From: Tony Russo <trusso0819@yahoo.com>
To: "JF@portlandmaine.gov" <JF@portlandmaine.gov>
Date: 1/22/2014 4:06 PM
Subject: 118 Congress Street Project

January 22, 2014

Dear Portland Planning Board |Members,

1 NORTH ELEVATION
1/8" = 1'-0"

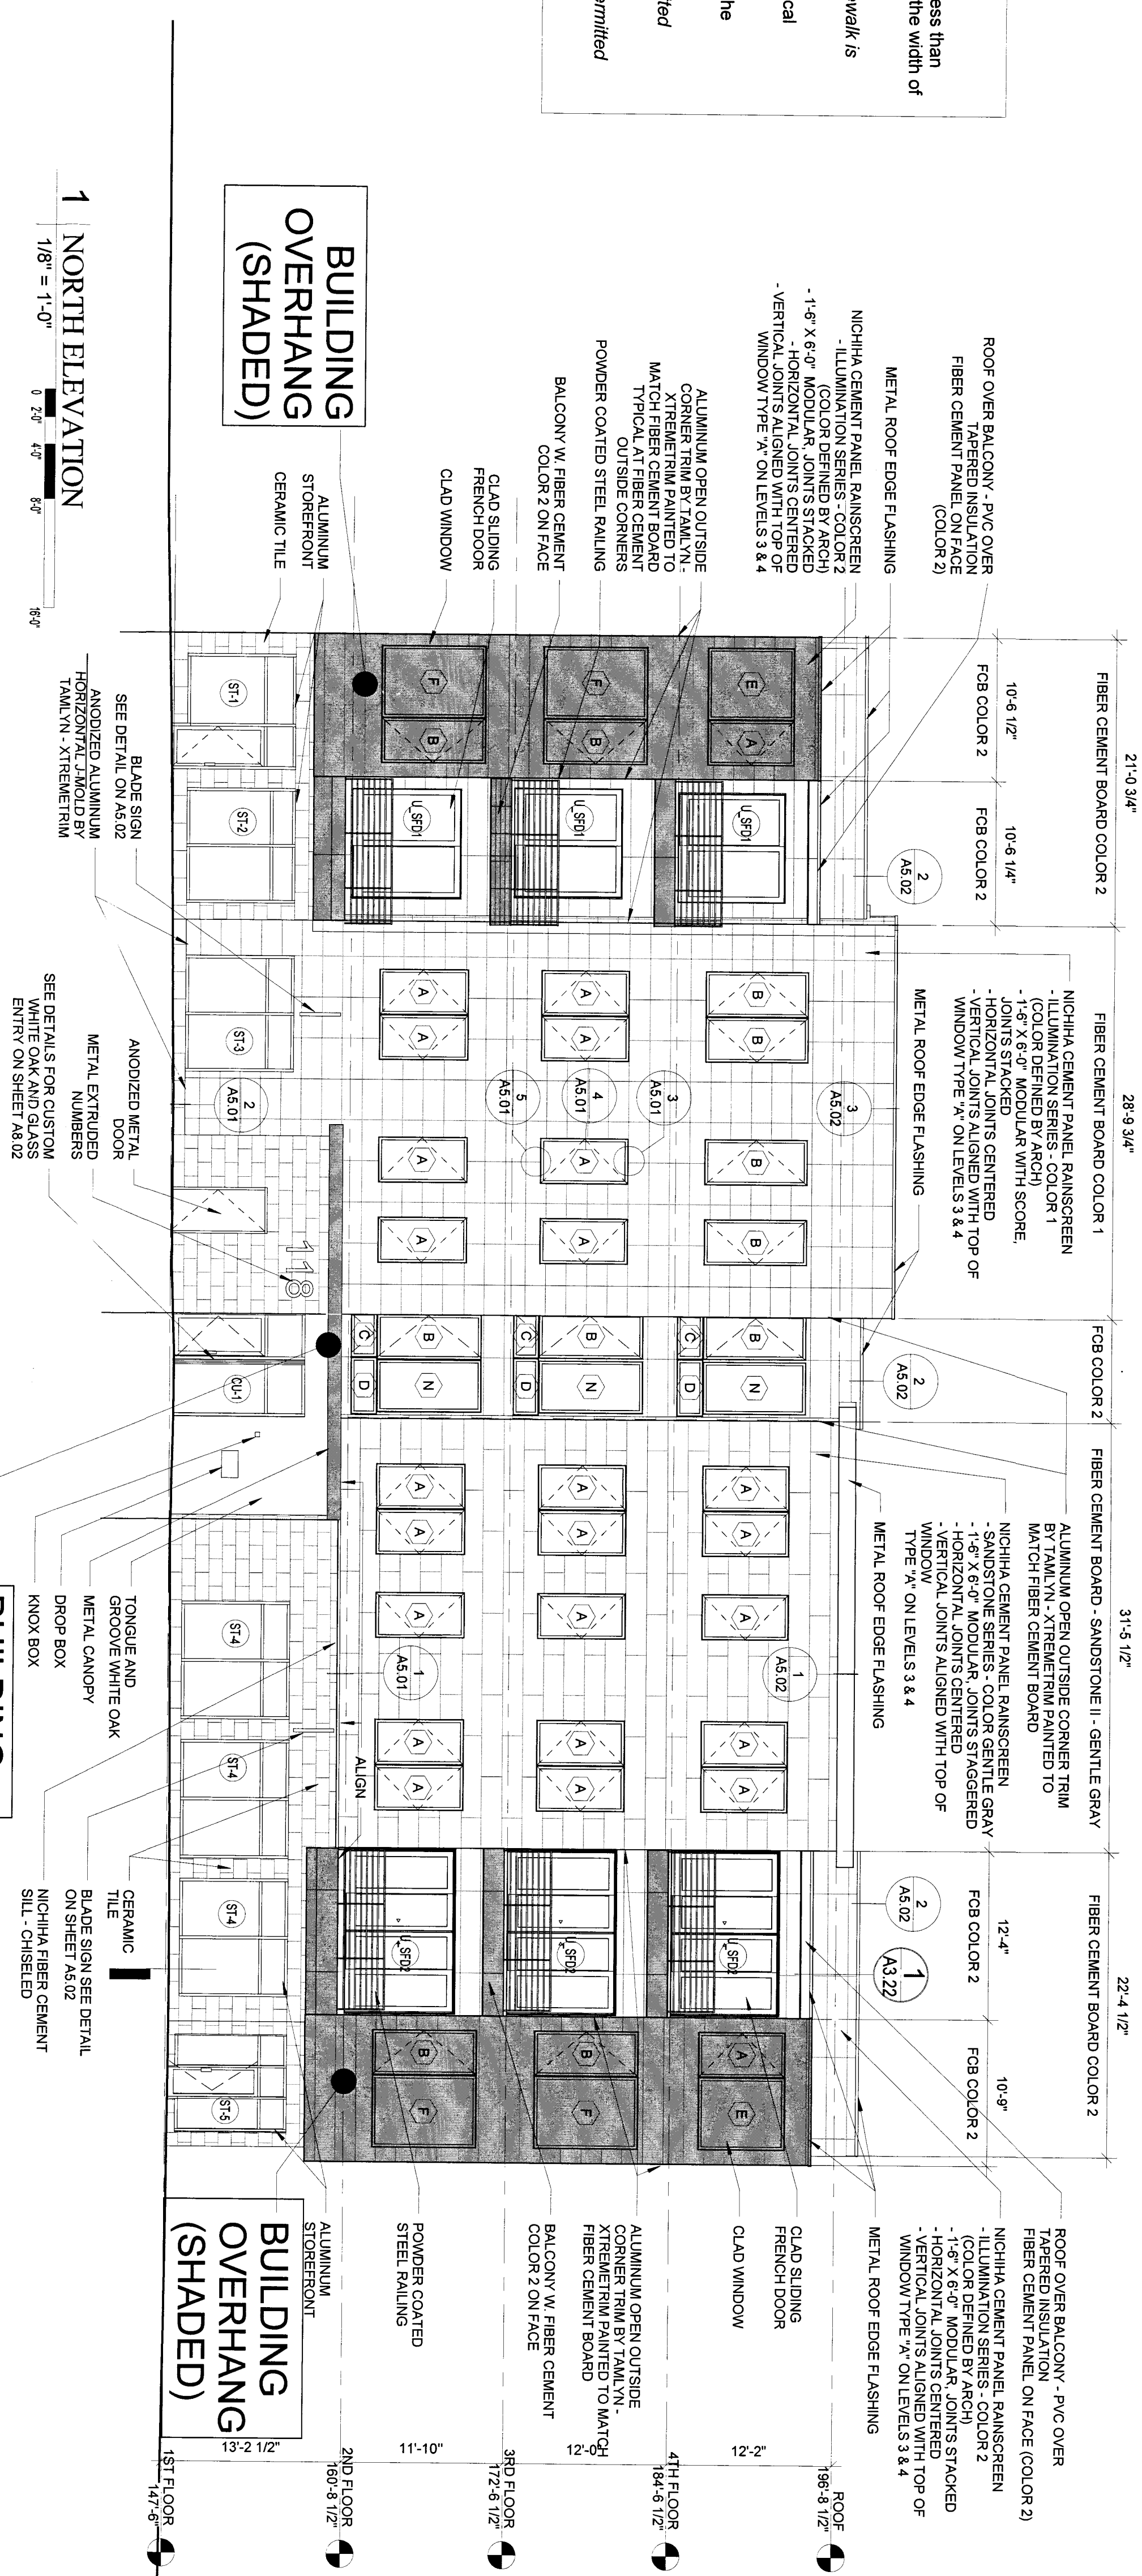
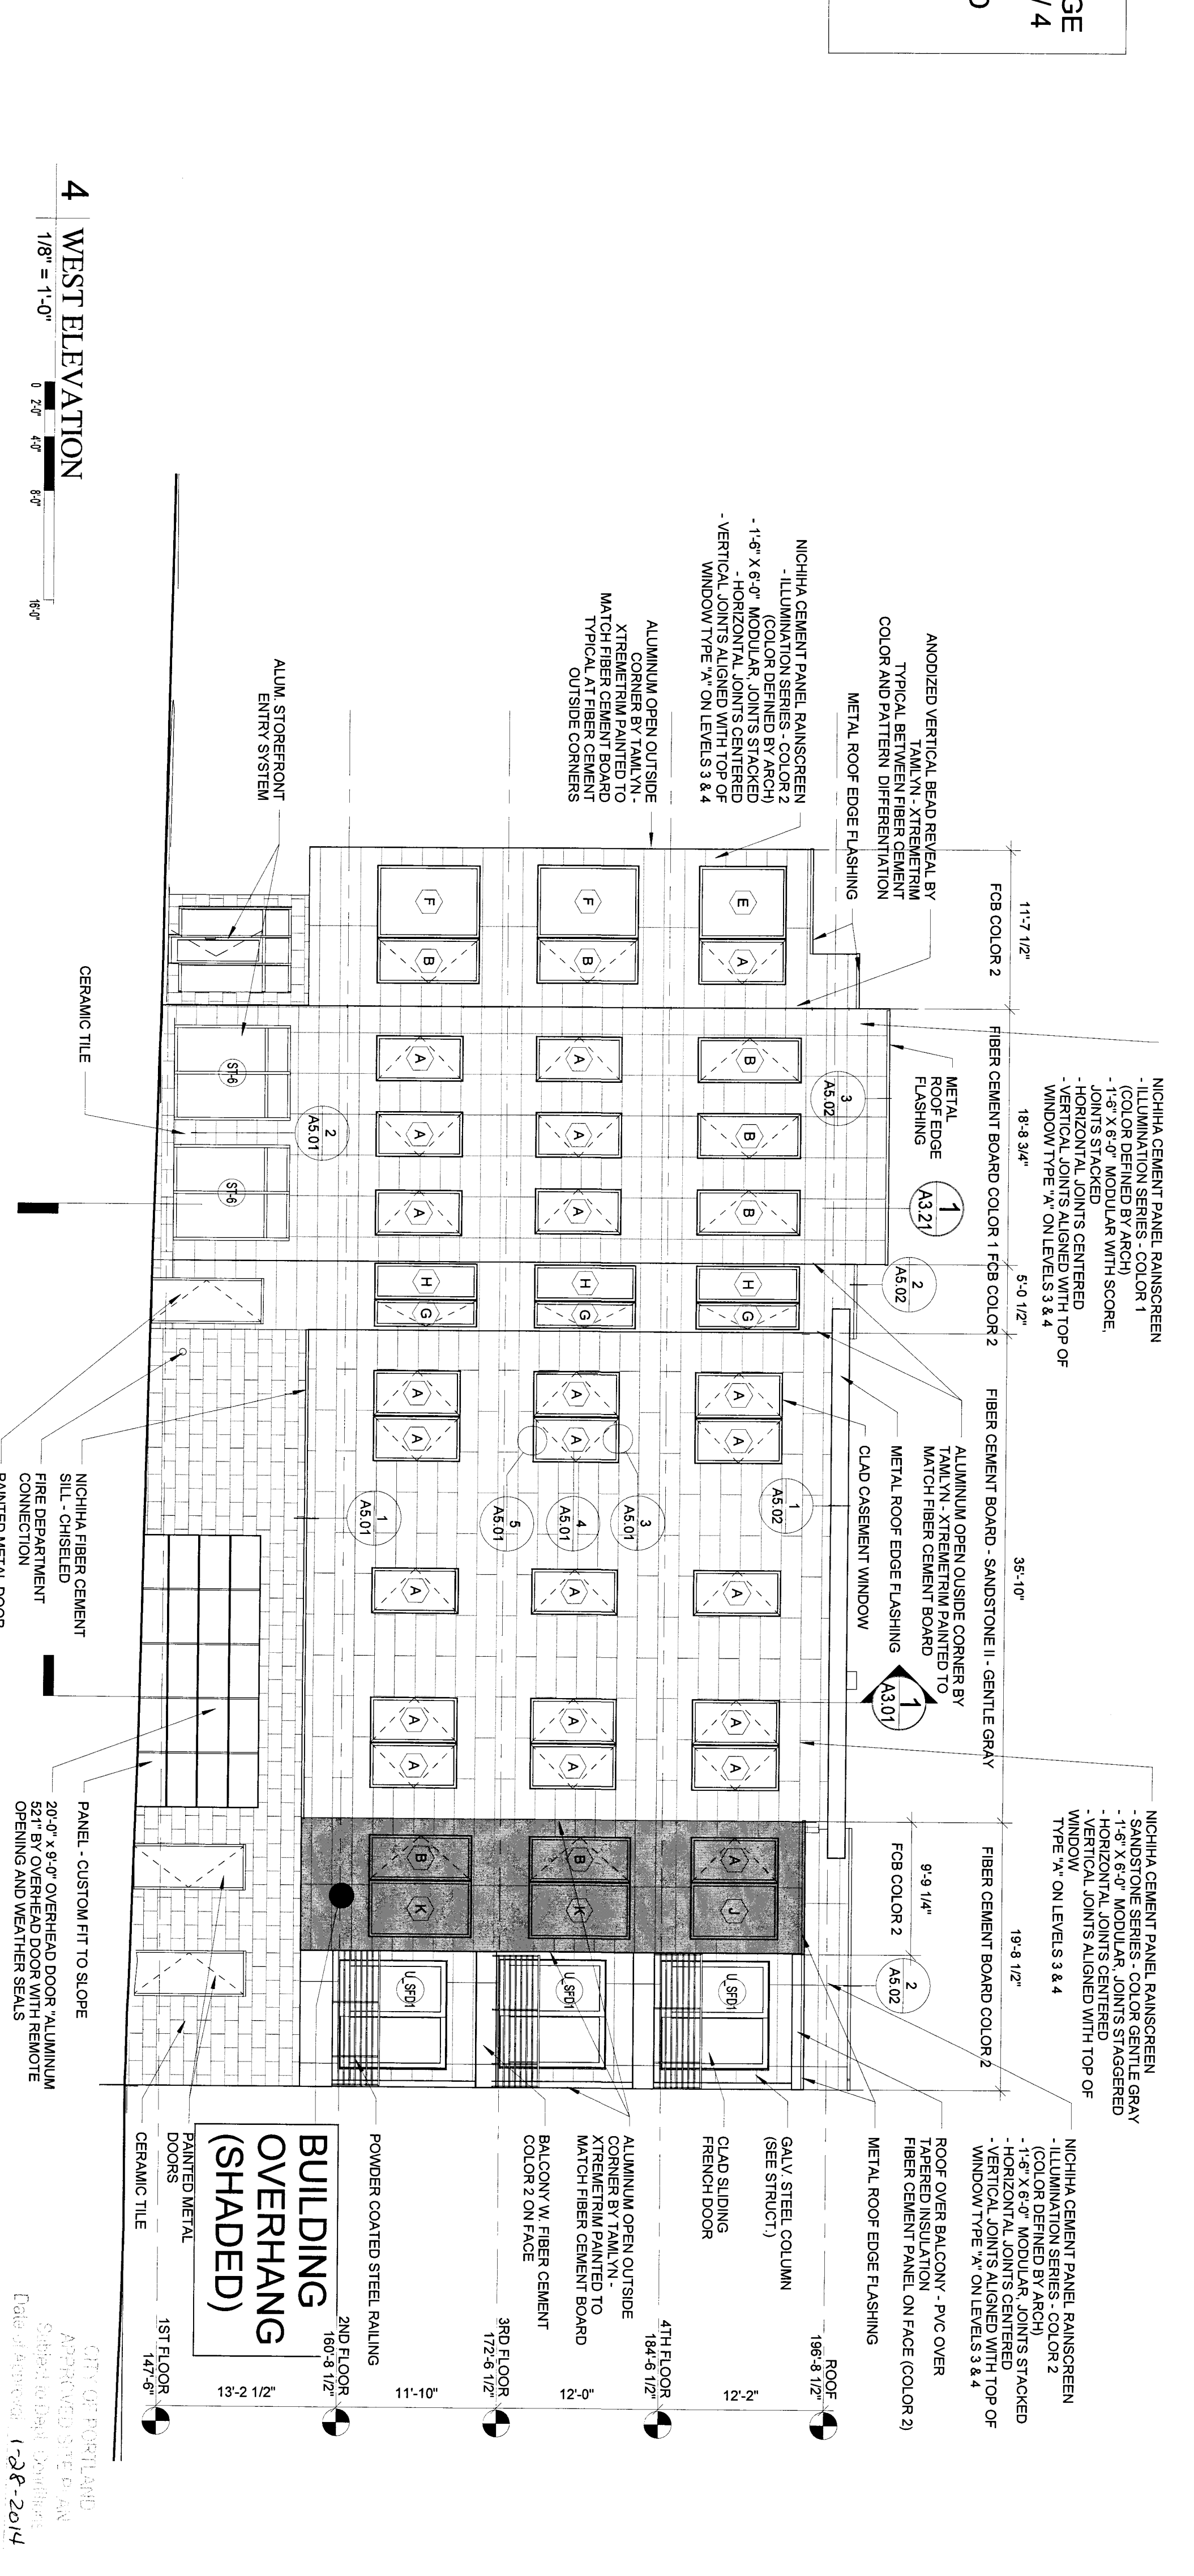
This proposed project is not in keeping with the neighborhood in terms of its design mass and scale. It will directly overshadow two streets on Munjoy Hill and its bulk will dominate the neighborhood. The overhangs of the sidewalk will provide hazards in terms of falling ice. The size makes the intersection with Congress Street dangerous.
